RFI

RFI #: 163
 Date: 6/26/2012
 Job: EB-02 Keller Springs Lofts
 Phone: 877-777-5115

Subject: Steel Beam at SW Corner of Fitness

**A2-SP ONE BEDROOM/ONE BATH**  
SCALE 1/4"=1'-0"

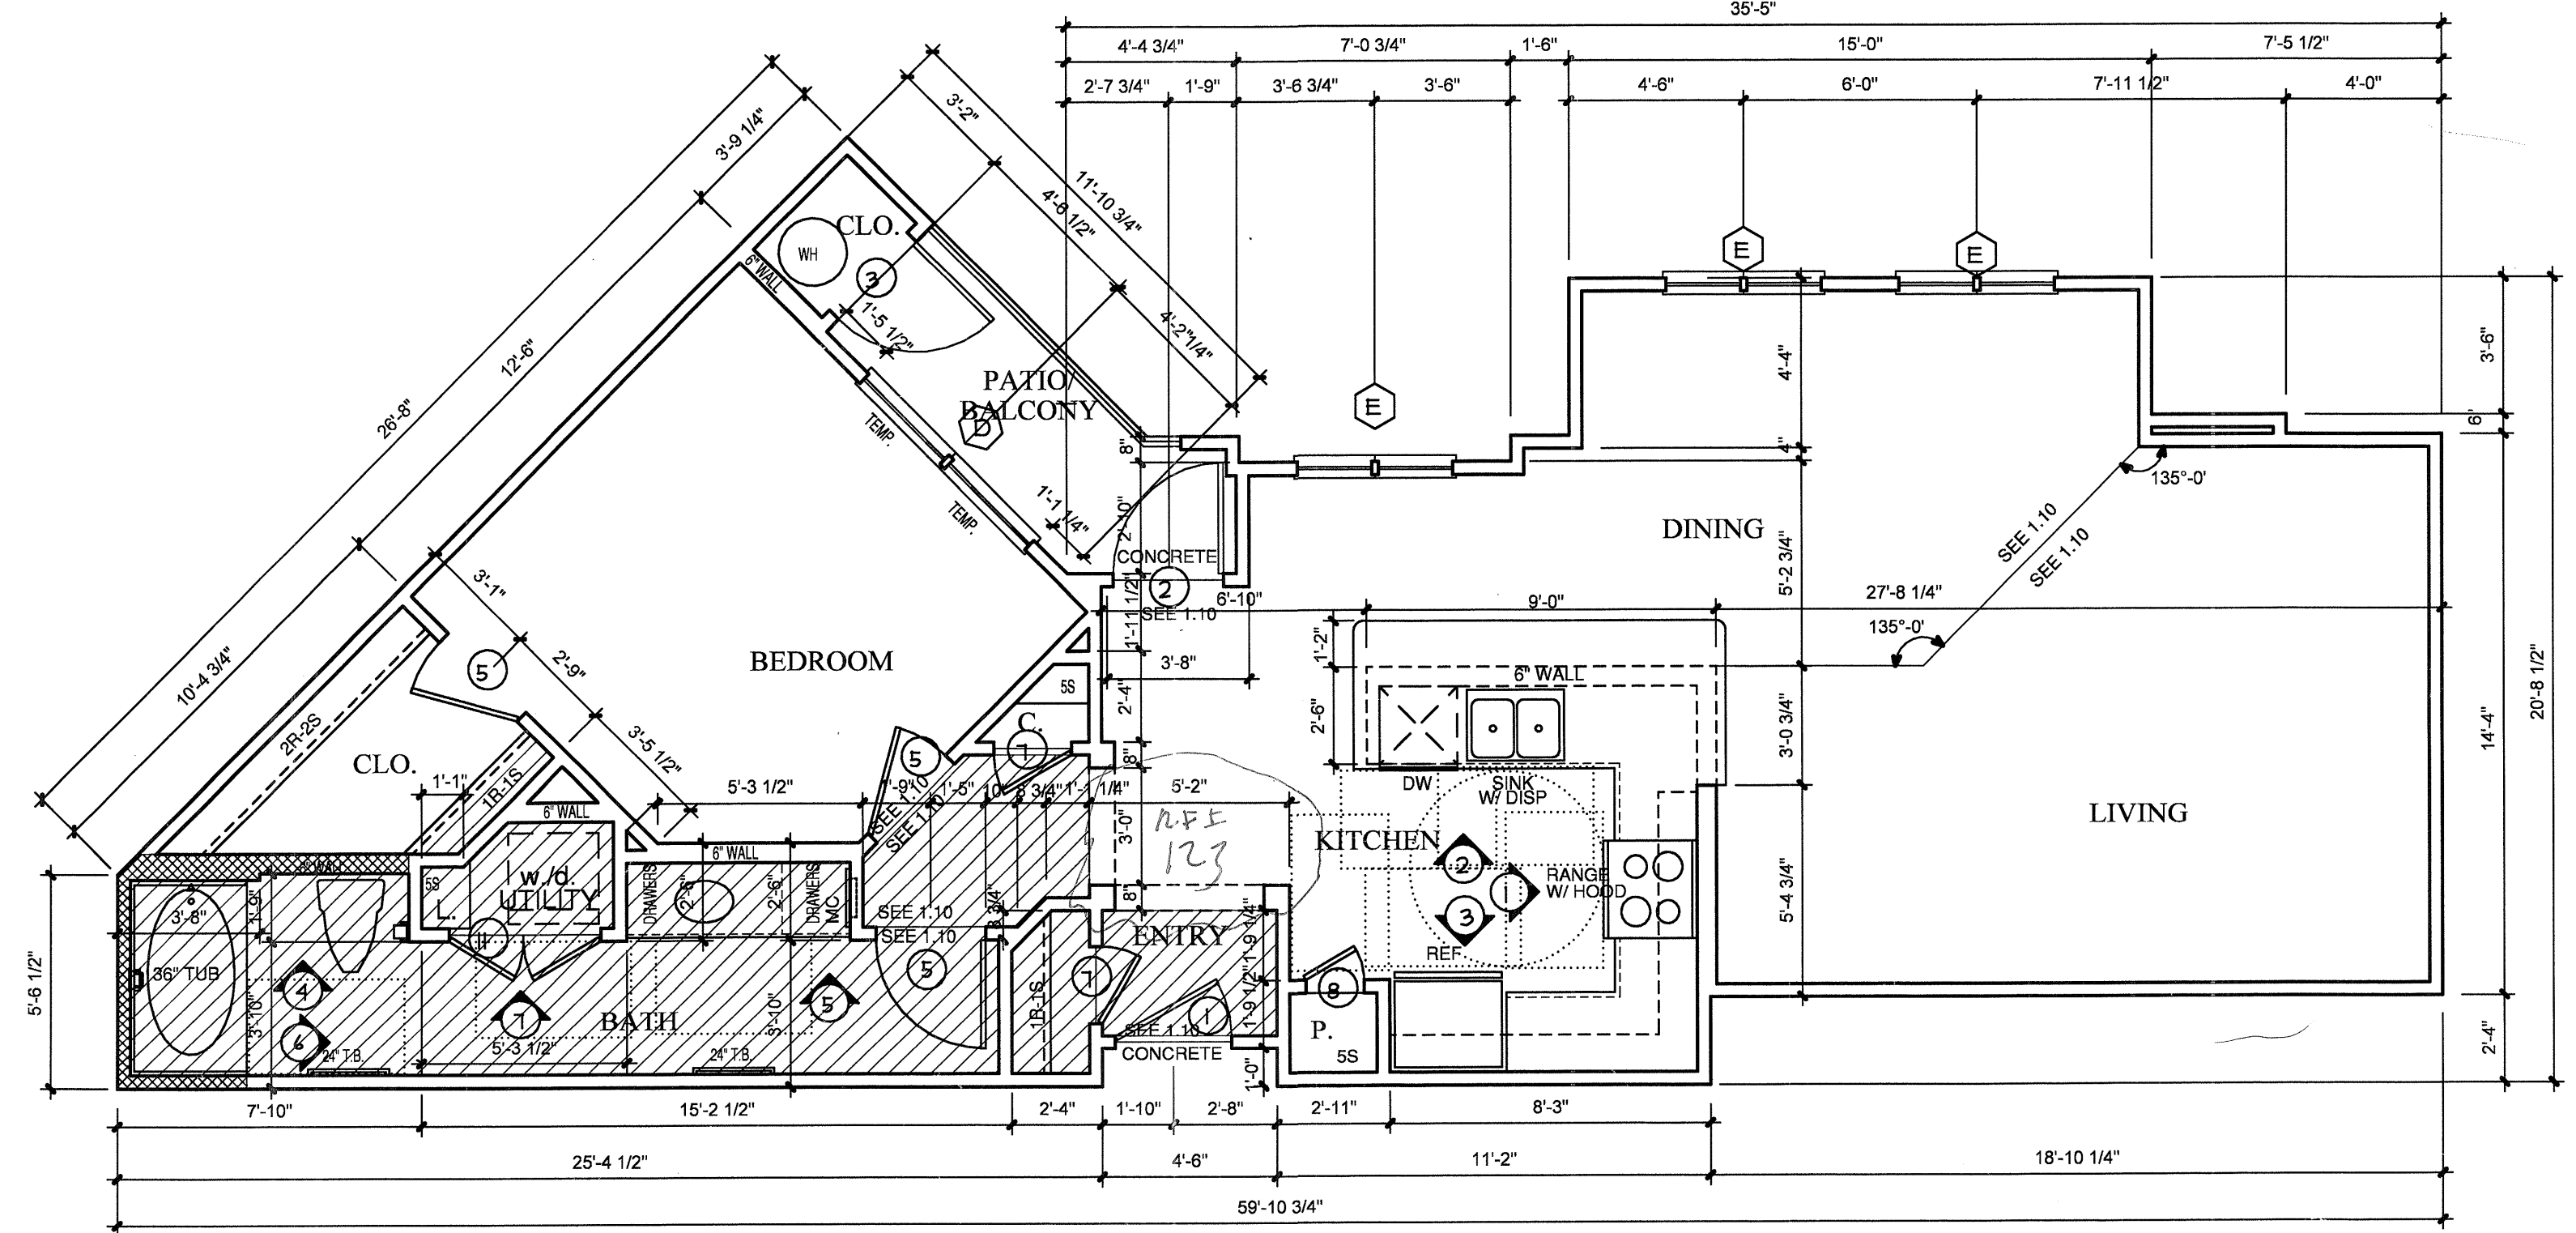
Request: Date Required: 6/11/2012
 There are several places on these drawings that appear to show steel beams centered on exterior walls. The largest beam is 10.25" wide looks like it is centered on a 3.5" wall. Please confirm that the dimensions on the drawings have been coordinated with Architectural drawings and with steel sizes and that none of the beams are going to affect the exterior skin.

PPO's response to RFI 176 cleared up this issue on the A2-SP unit above the garage entry.
